980703

Location of Construction: 29 Exchange St	Owner: Baker/Canele	Phone:						
Owner Address:	Lessee/Buyer's Name: Fuji Restaurant	Phone:						
Contractor Name: Berr Sign	Address: 10 Suttonwood So. Portland, ME 04106	Phone: 799-1183						
Past Use: Restaurant	Proposed Use:	<table border="1"> <tr> <td>COST OF WORK: \$</td> <td>PERMIT FEE: \$ 28.60</td> </tr> <tr> <td>FIRE DEPT. <input type="checkbox"/> Approved <input type="checkbox"/> Denied</td> <td>INSPECTION: Use Group: Type:</td> </tr> <tr> <td>Signature:</td> <td>Signature:</td> </tr> </table>	COST OF WORK: \$	PERMIT FEE: \$ 28.60	FIRE DEPT. <input type="checkbox"/> Approved <input type="checkbox"/> Denied	INSPECTION: Use Group: Type:	Signature:	Signature:
COST OF WORK: \$	PERMIT FEE: \$ 28.60							
FIRE DEPT. <input type="checkbox"/> Approved <input type="checkbox"/> Denied	INSPECTION: Use Group: Type:							
Signature:	Signature:							
Proposed Project Description: Install non-illuminated ID signs	<table border="1"> <tr> <td colspan="2">PEDESTRIAN ACTIVITIES DISTRICT (P.A.D.)</td> </tr> <tr> <td>Action:</td> <td> <input type="checkbox"/> Approved  <input type="checkbox"/> Approved with Conditions  <input type="checkbox"

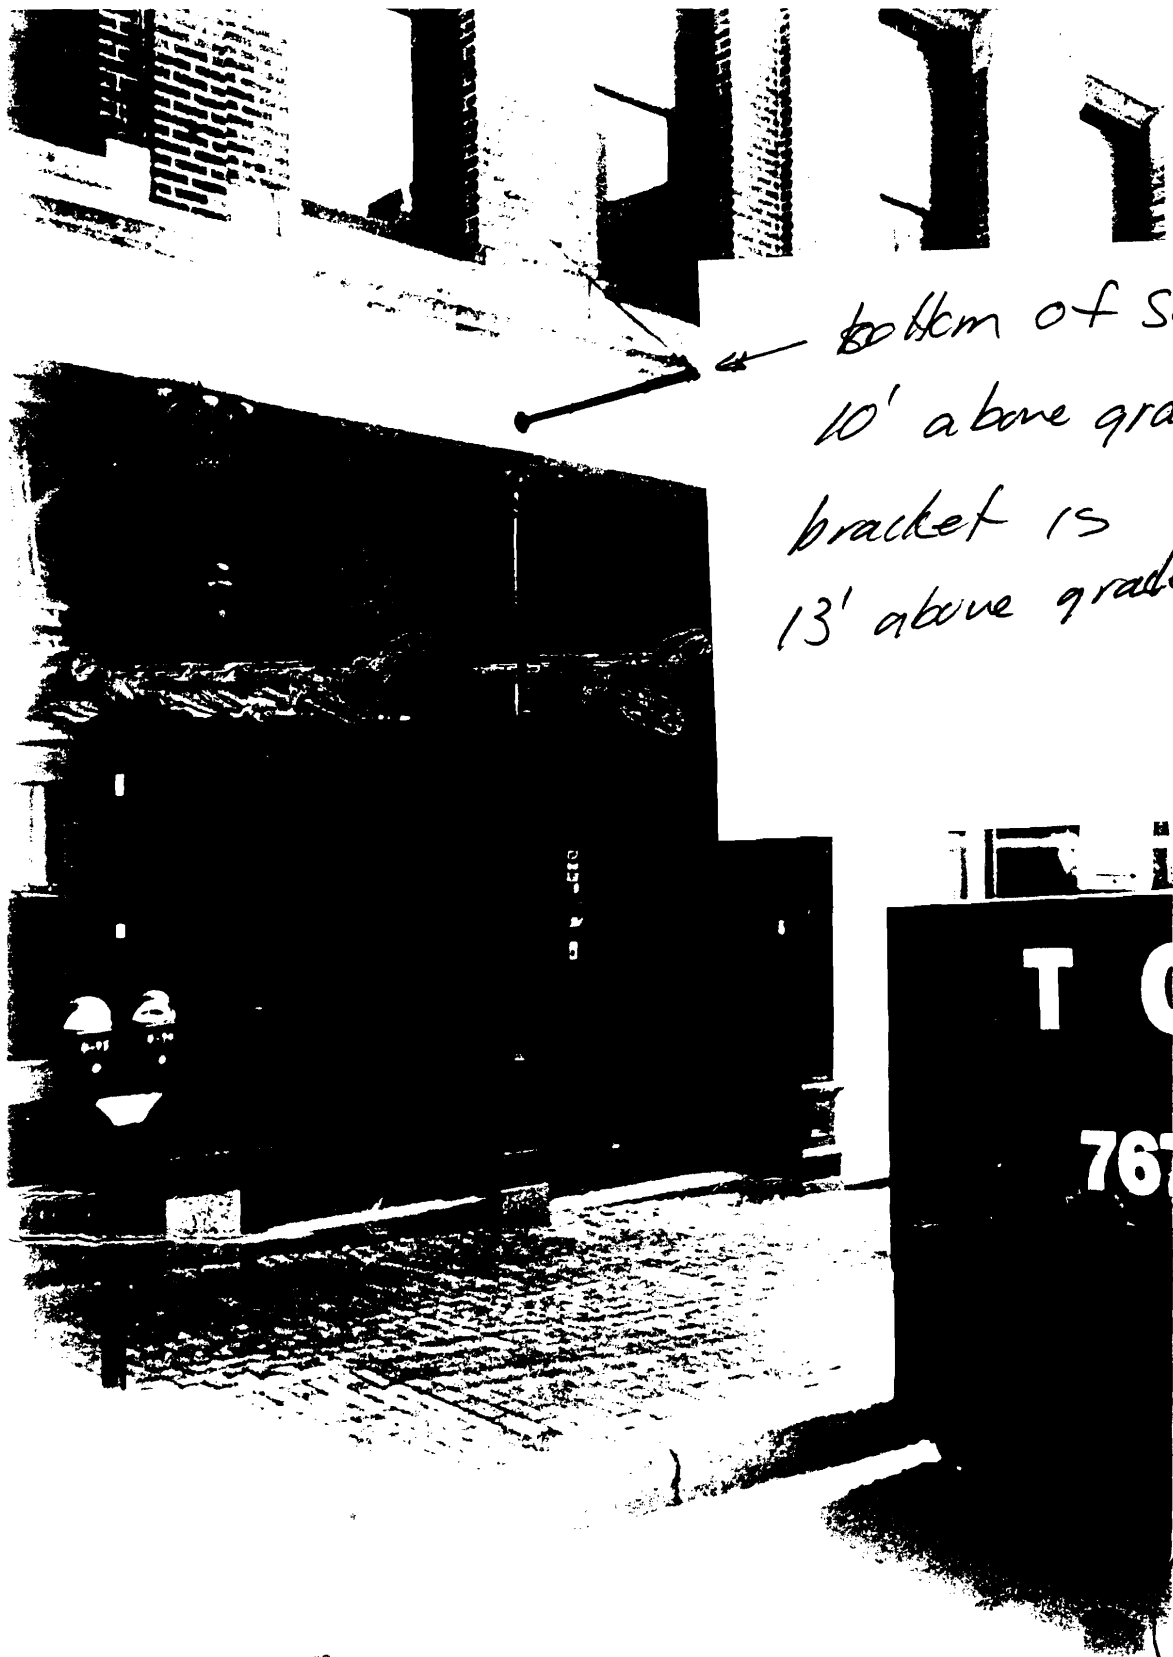
29. *Sign on middle ST facade to be relocated to the East, at least at middle of storefront, also lowered to hang over storefront window. Exact position to be reviewed & approved by Historic Preservation Staff.*

30. *No structural detail was submitted with your sign application. Please submit these details before hanging sign.*
